From: [Peter Bleasdale](#) on behalf of [Airspace Protection](#)
To: [Andrew Watson](#)
Cc: [Minoshi Weerasinghe](#)
Subject: HPE CM: Notice of Exhibition - 104-116 Regent Street, Redfern – Student Accommodation (SSD-12618001) - RESPONSE - SYDNEY AIRPORT
Date: Monday, 31 January 2022 2:54:20 PM
Attachments: [image002.emz](#)
[image003.png](#)

The Department of Planning and Environment has received an Environmental Impact Statement (EIS) for 104-116 Regent Street, Redfern – Student Accommodation (SSD-12618001).

DRAWING TITLE
Northern Elevation + Southern
Elevation

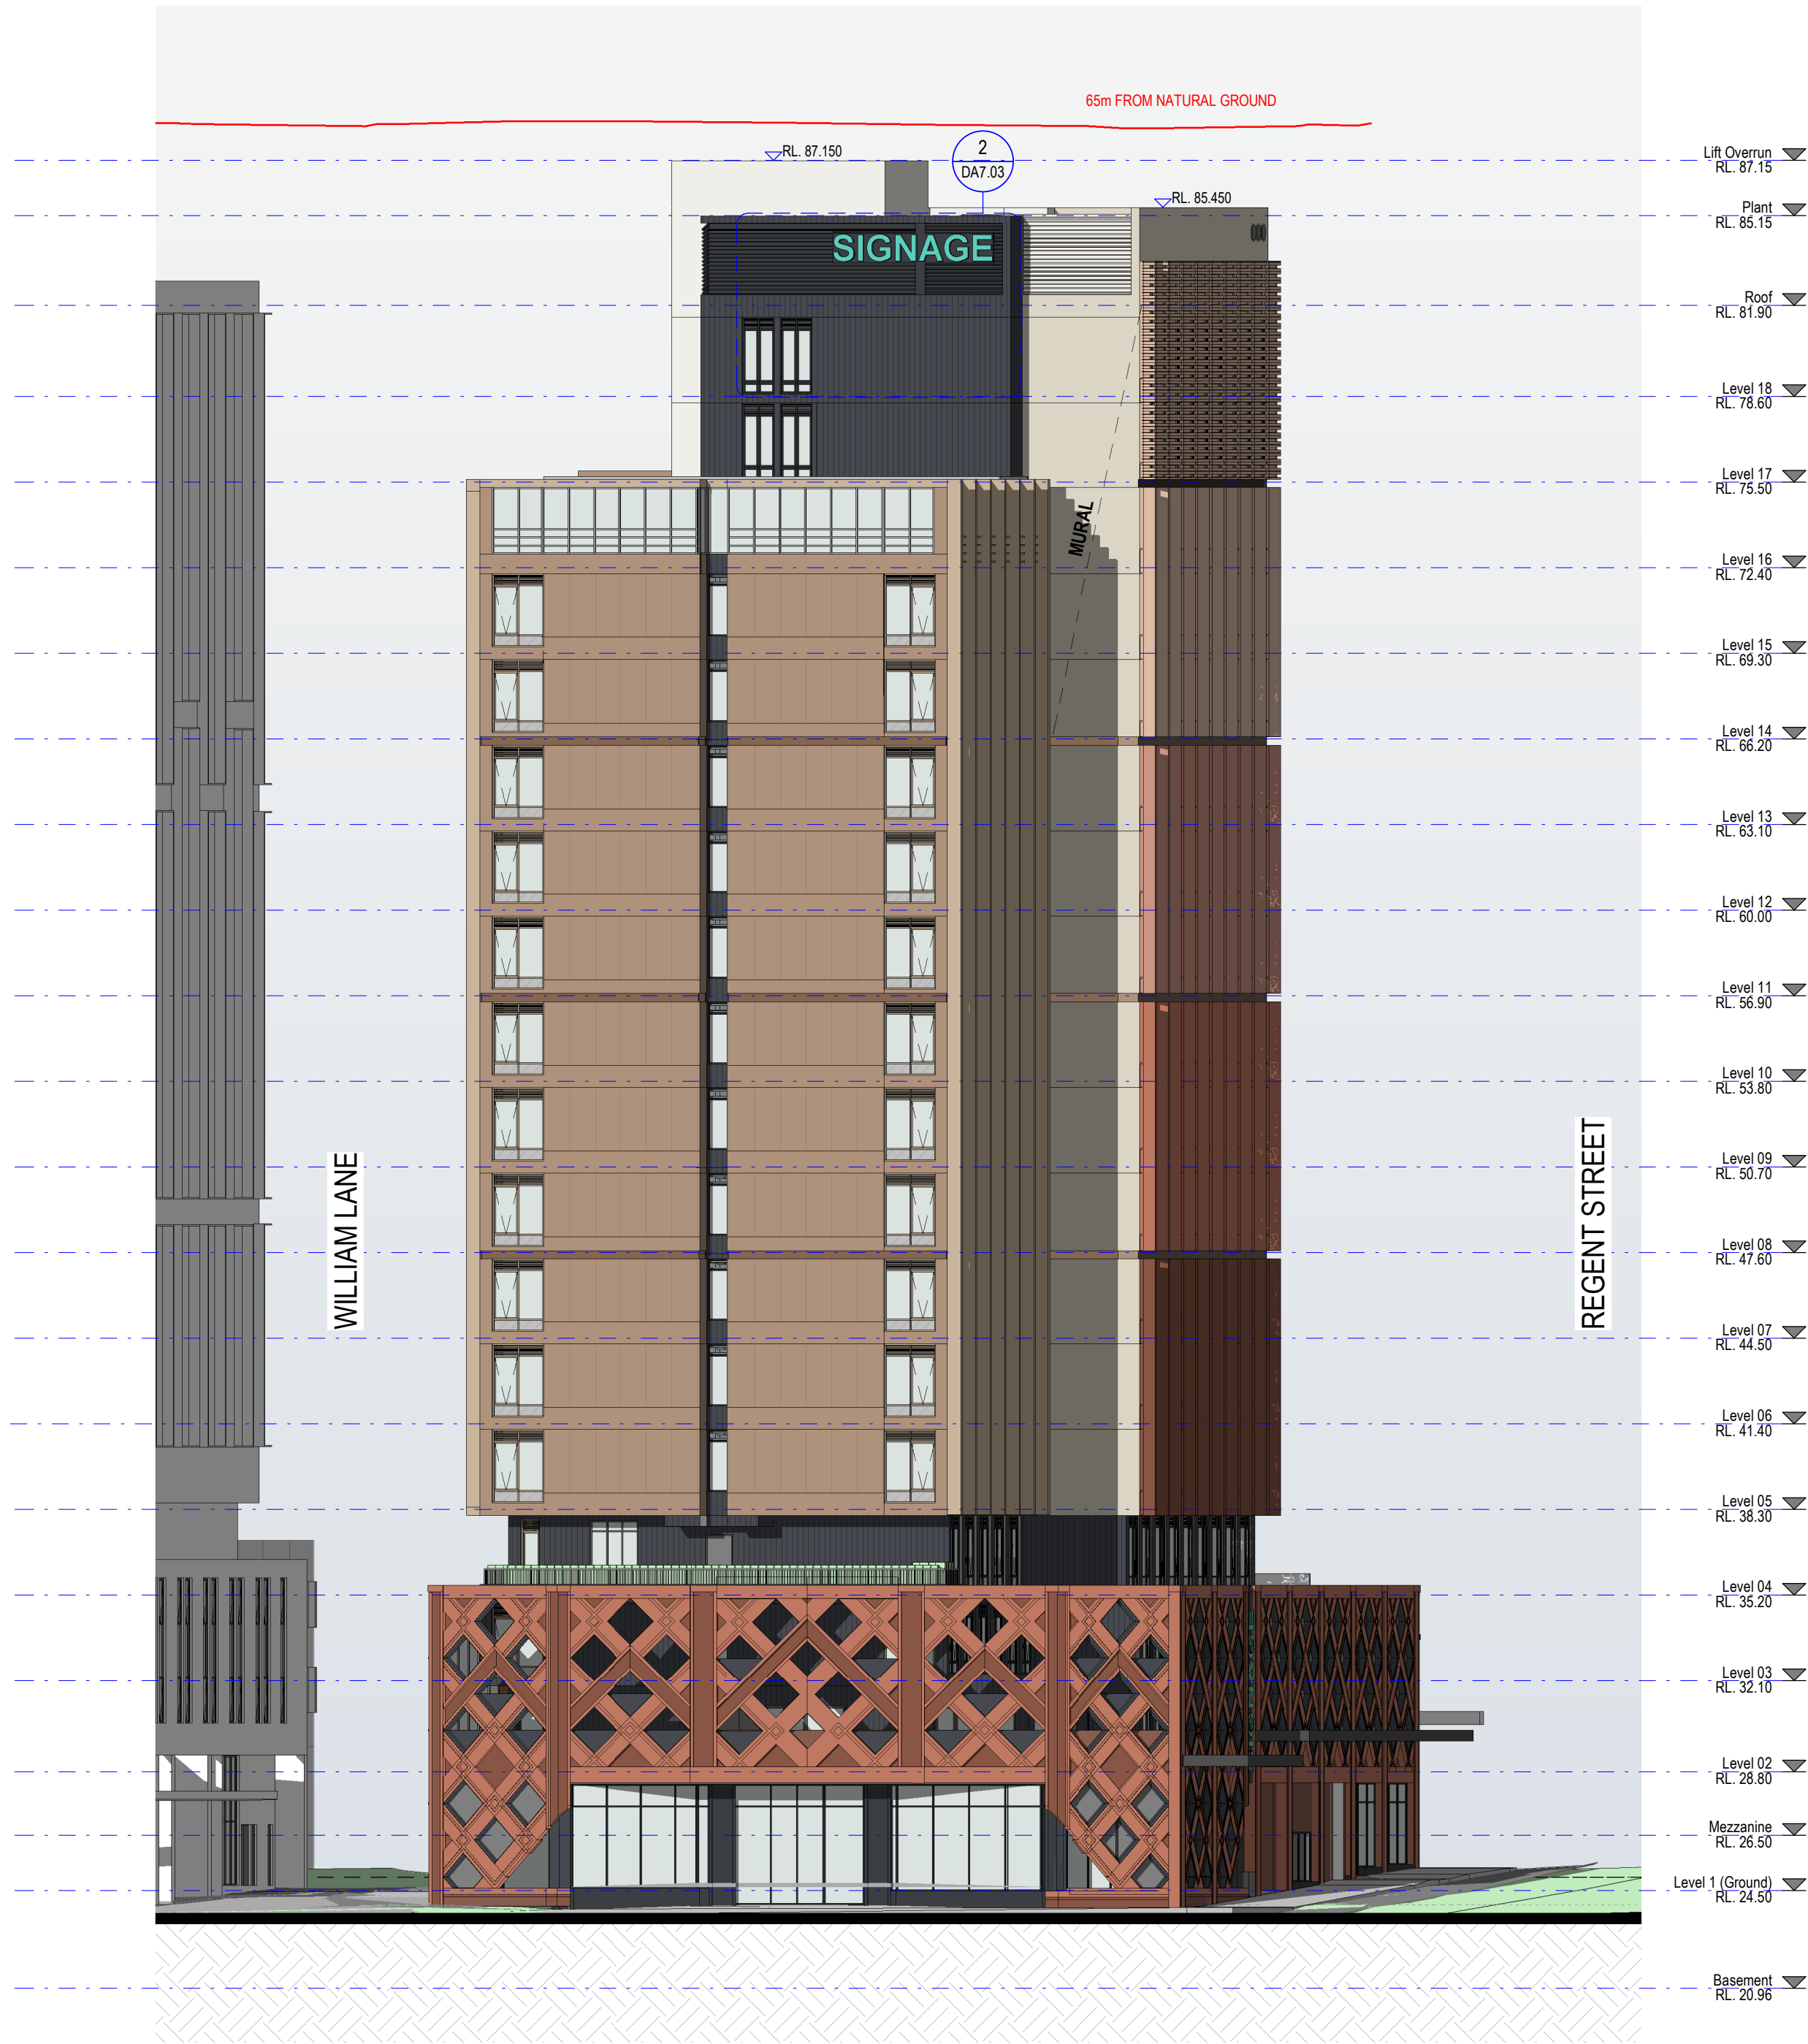
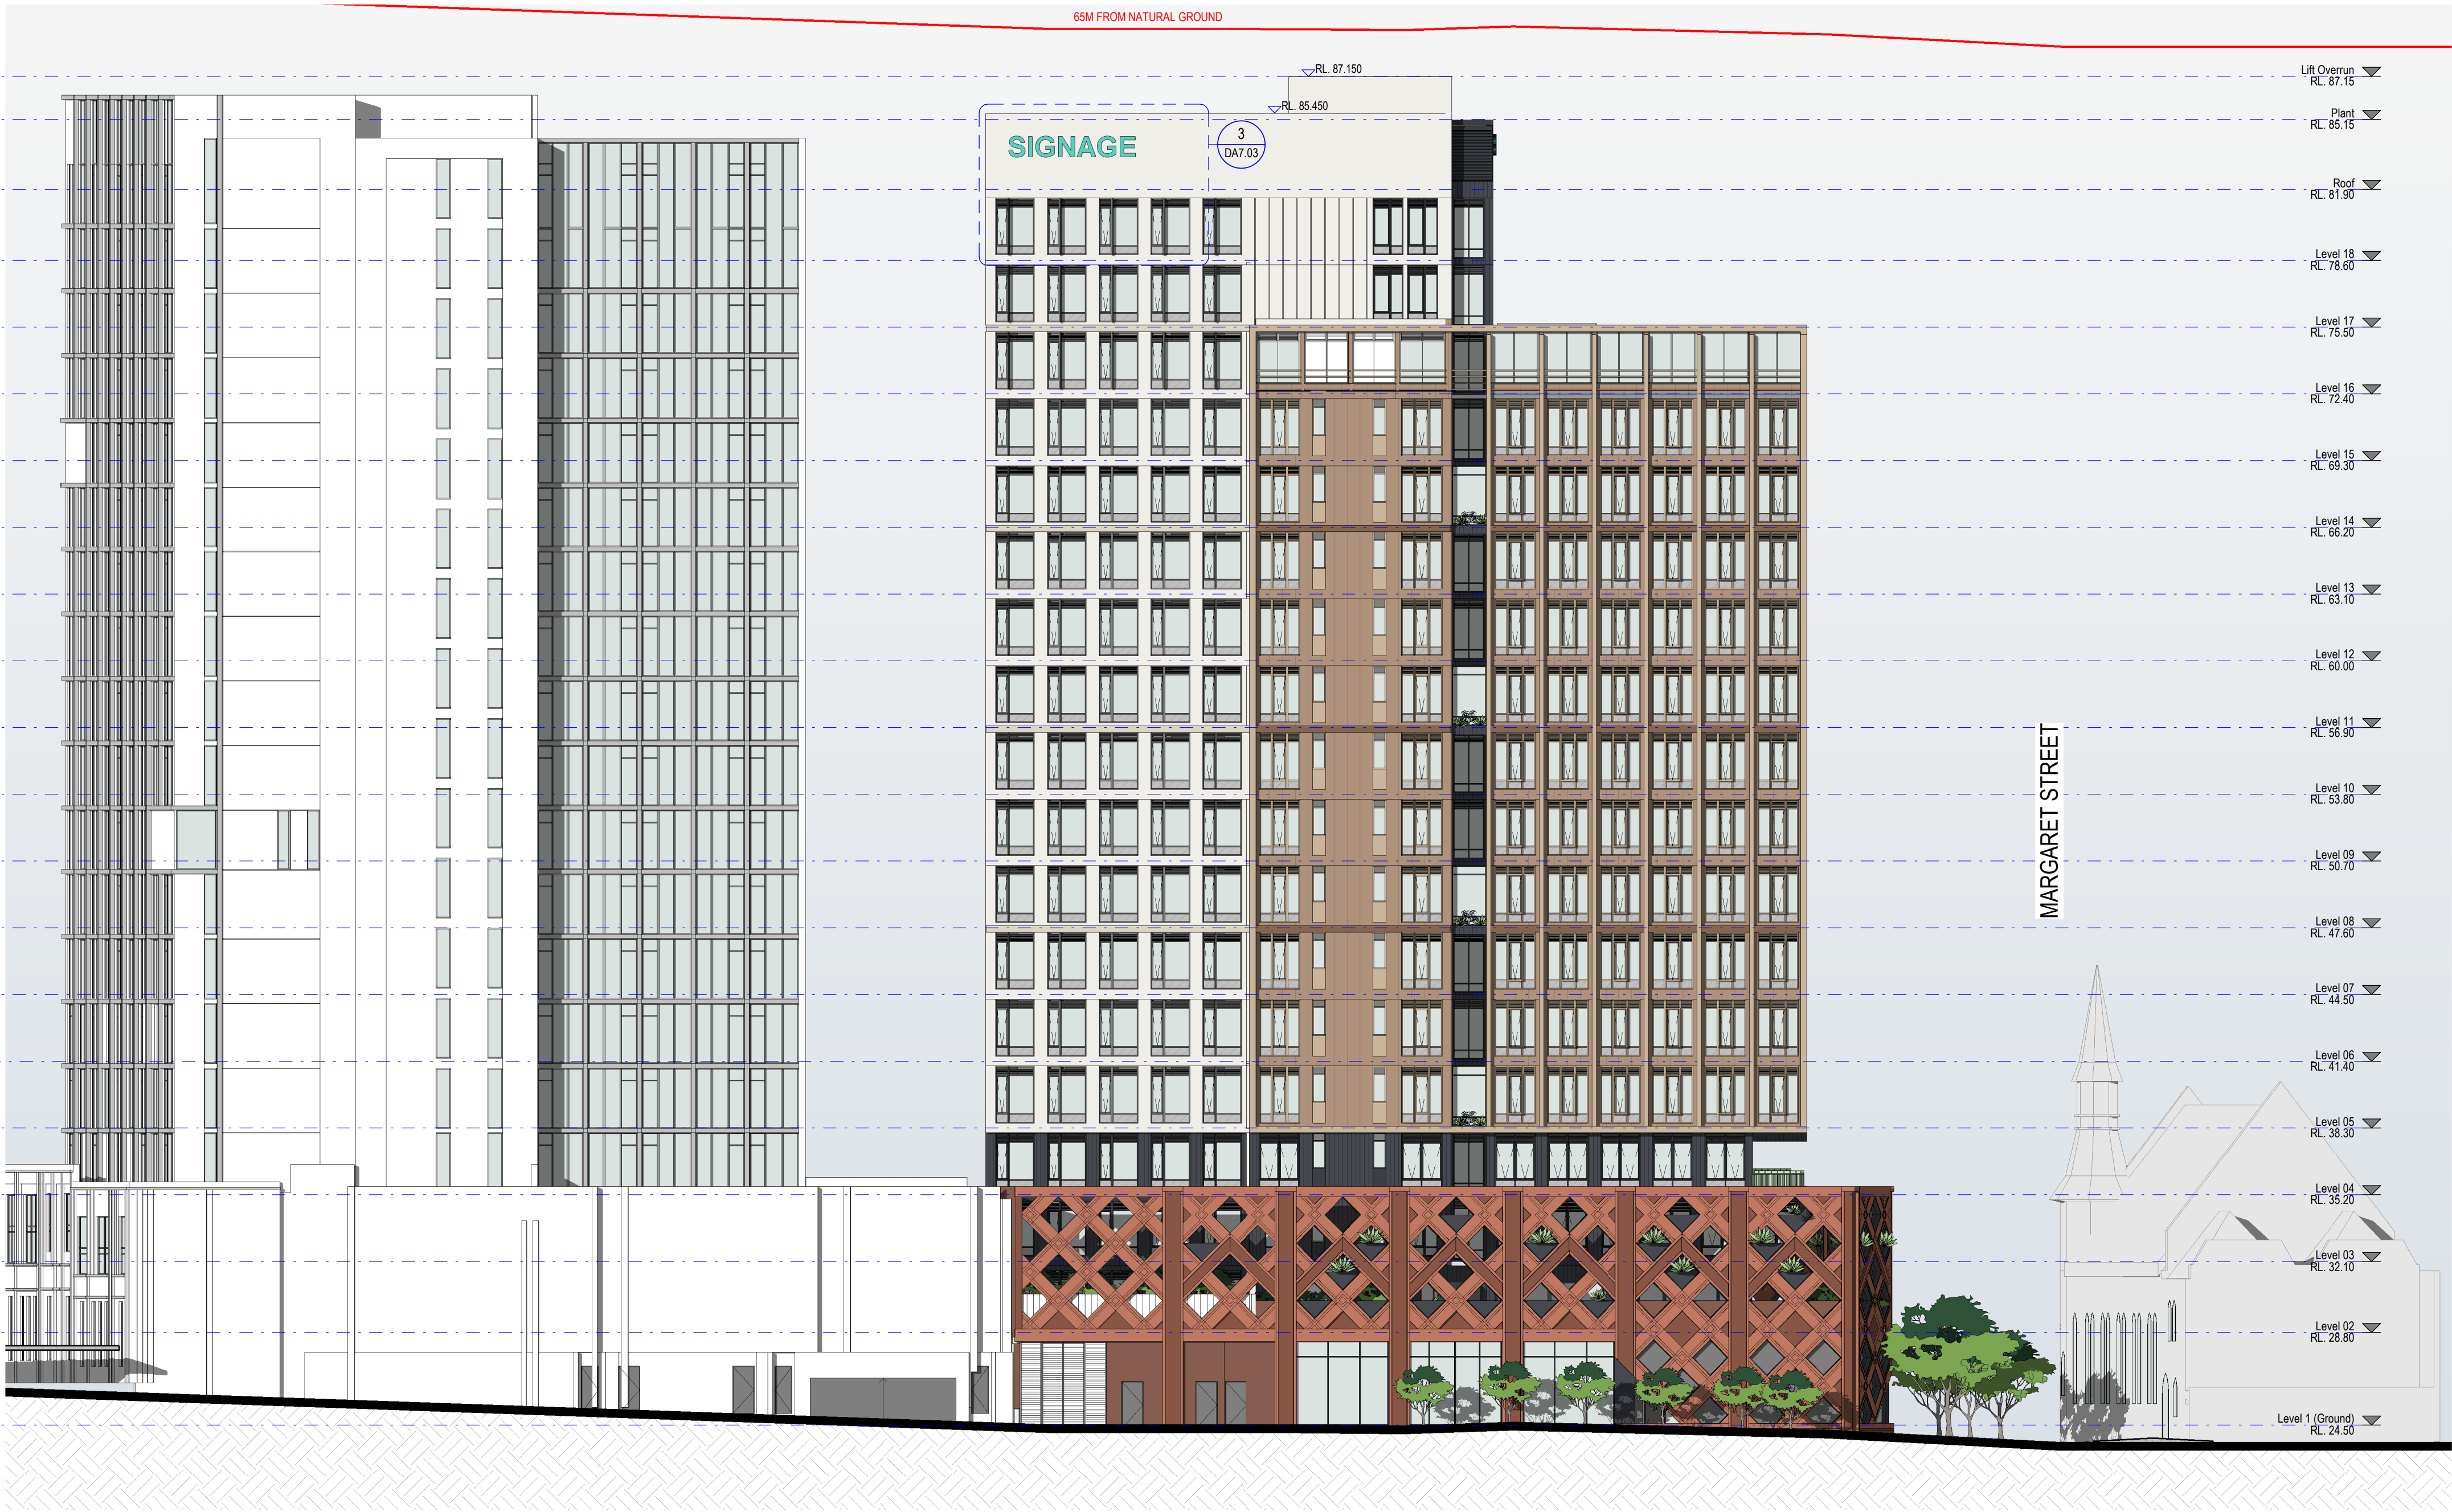
The approximate height of Sydney Airport's Obstacle Limitation Surface (OLS) over the site is 82m AHD.

With a maximum height of the proposed development is 87.15 which would penetrate the OLS and be considered a controlled activity.

Under the Federal "Airports (Protection of Airspace) Regulations 1996" the proposed development would need to be assessed & a determination made by the Federal Department of Infrastructure, Transport, Regional Development and Communications prior to construction.
